**KIRKLEES METROPOLITAN COUNCIL
INVESTMENT & REGENERATION SERVICE**

DELEGATED DECISION TO DETERMINE PLANNING APPLICATIONS

Reference No:	2024/62/93294/W
Site Address:	43, Leafield Avenue, Longwood, Huddersfield, HD3 4TW
Description:	Erection of two storey side and single storey rear extensions
Recommending Officer:	Joanna Rednall

DECISION - REFUSED

Proposed Elevations

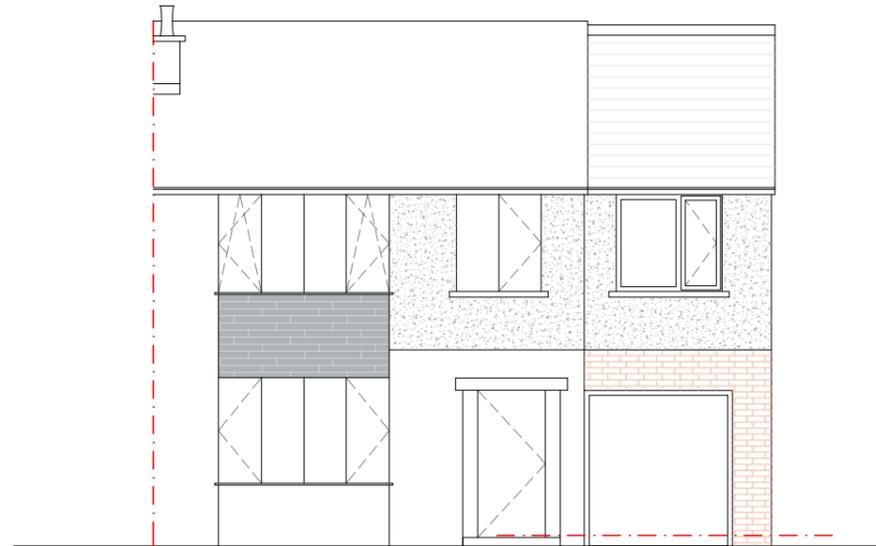
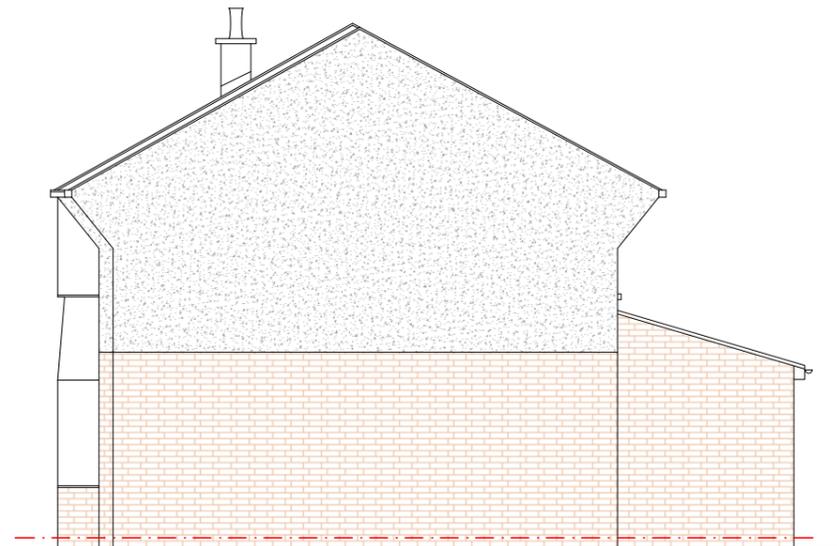
The proposal would have its bulk and massing set back ~0.3 metres from the front elevation closest to the highway and closely matching the roof ridge height to the host, with only a set down of ~0.05 metres achieved. There would not be a gap left to the side.

There are no examples of two-storey side extensions built up to the boundaries within this immediate building group. The host sits within a similarly designed trio of semi-detached properties along Leaffield Avenue and as such, without a 1 metre separation from the side boundary, the proposed additional massing combined with the lack of set back and set down as recommended in the SPD, the host would appear incongruous and dominant to its neighbouring properties and within the street scene. This would add an impression of a cramped form of development in an area where dwellings are more spaciouly separated through design and scale.

The development would take up all the space to the side closing the gap between semi-detached houses and eroding the sense of space which is a positive characteristic of the street scene. The development also includes parking to the entire front garden which would be dominated by large areas of hard surfacing and parked cars thereby negatively impacting upon the character of the street scene.

In conclusion, the two-storey side extension would present an incongruous, cramped and overly prominent appearance to the street scene and a dominant addition to the host causing visual harm to both the host dwelling and the character and appearance of the wider area. To permit the development would be contrary to Policy LP24 (a and c) of the Kirklees Local Plan, Key Design Principles 1 and 2 of the adopted House Extensions and Alterations SPD, and Chapter 12 of the National Planning Policy Framework.

1. The proposed two-storey side extension would take up all of the space to the side of the house and fail to maintain a 1.0 metre gap to the side boundary to ensure the building is not too close to a neighbouring property. As such it would close the gap between semi-detached houses and further erode a sense of space between houses which is a positive characteristic of the street-scene. This does not promote good design and is contrary to Policy LP24 of the Kirklees Local Plan and design guidance given in sections 4.1, 4.2, 4.3, 5.19, 5.20 & 5.21 of the Kirklees House Extensions Supplementary Planning Document.
